19 October 2021

Reference: CN185737

RE: SSD-10468 Woolworths Warehouse and Customer Fulfilment Centre, Marrickville

OVERALL STORMWATER PLAN GROUND LEVEL	
DATE:	AUGUST 2020
SCALE:	1:500 @A1
Project No.	190372
DRG.No.	C01
REV-B

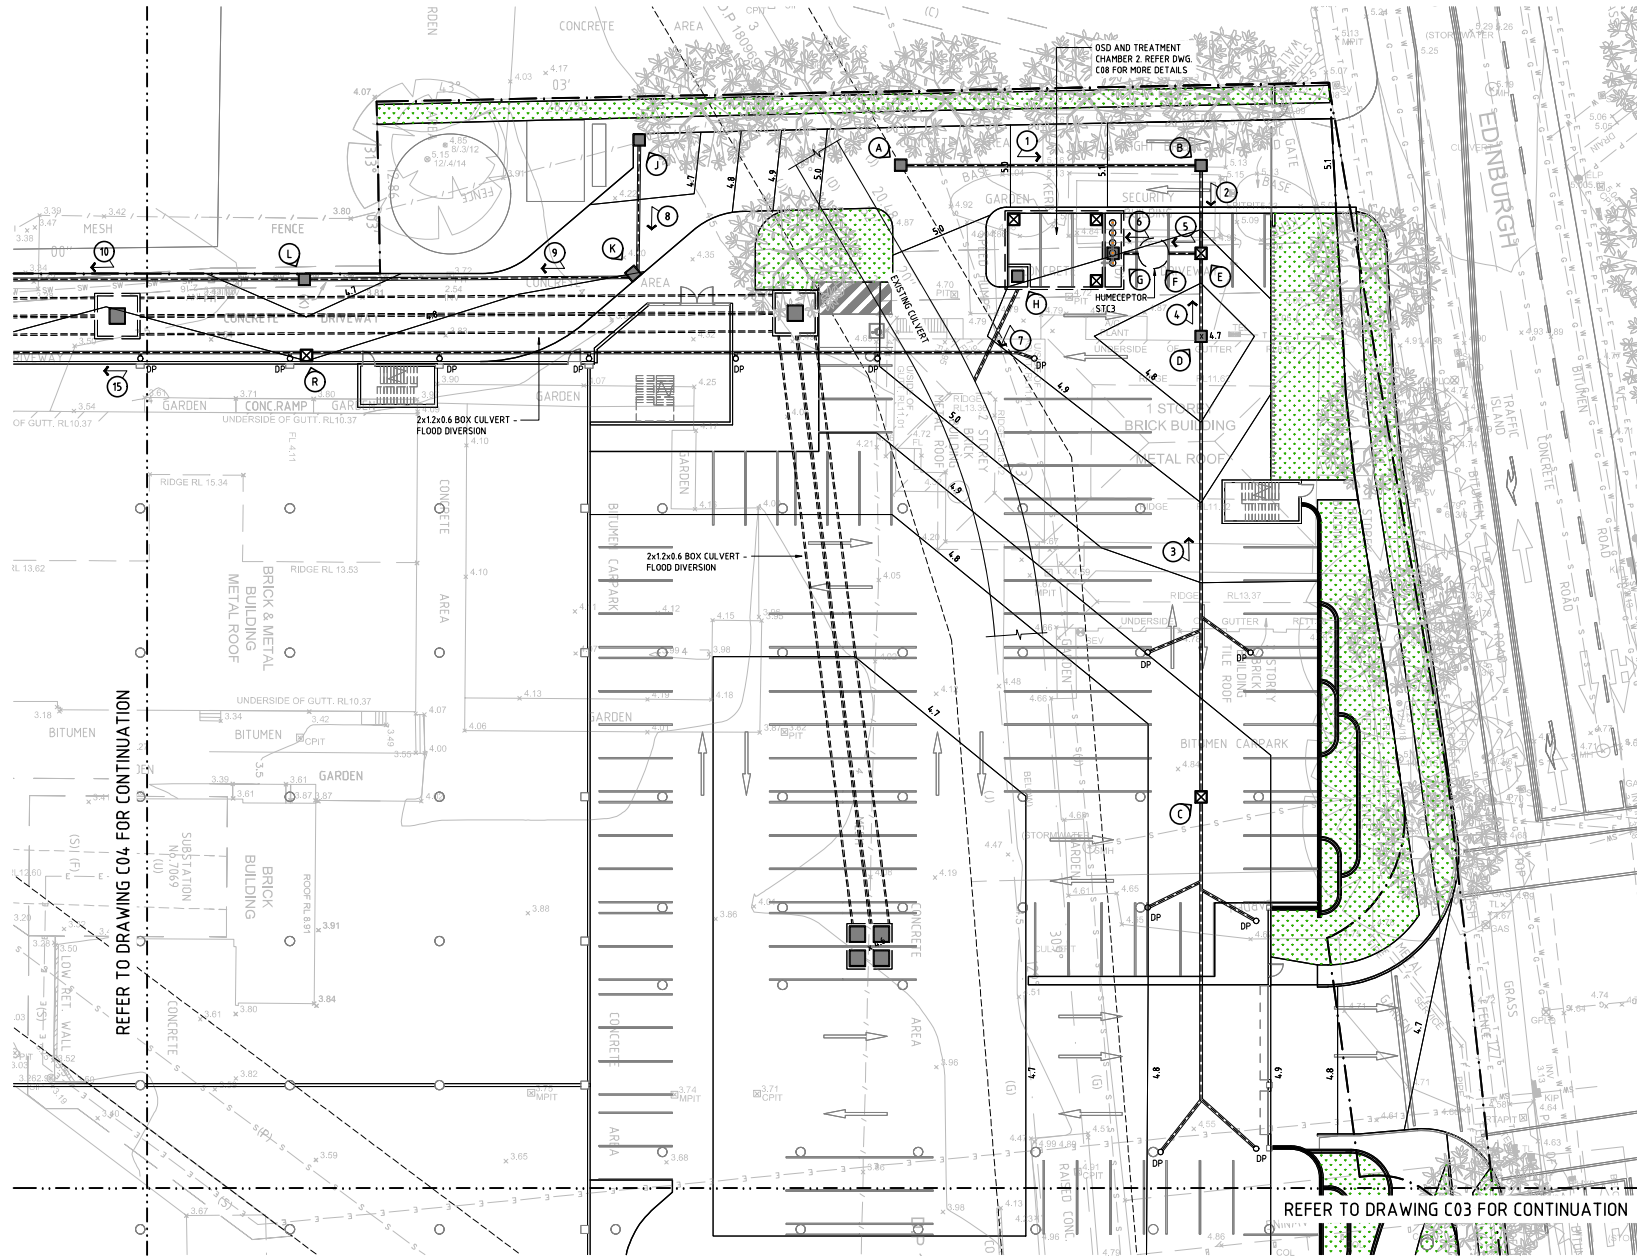
- Deviation path of the stormwater channel is to be as per the submitted sketch "SK10 Rev B Dated 08.10.20" (Attachment 1) and noted under case 185737
- Culvert size is to be 3,000mm x 1,500mm (Proponent has confirmed that the capacity of this pipe would be equal or larger than existing capacity of the channel)

Horizontal clearance from deviated stormwater pipe along north-western boundary (boundary with 76A Edinburgh Road, Marrickville)

- Horizontal clearance between the north-western boundary and outside face of the stormwater channel is to be minimum 600 mm.
- Horizontal clearance between any buildings and outside face of the stormwater channel is to be 1,000 mm

Horizontal clearance from deviated stormwater pipe along north-Eastern boundary (boundary along Edinburgh Road)

- Horizontal clearance between any buildings and outside face of the stormwater channel is to be 600 mm
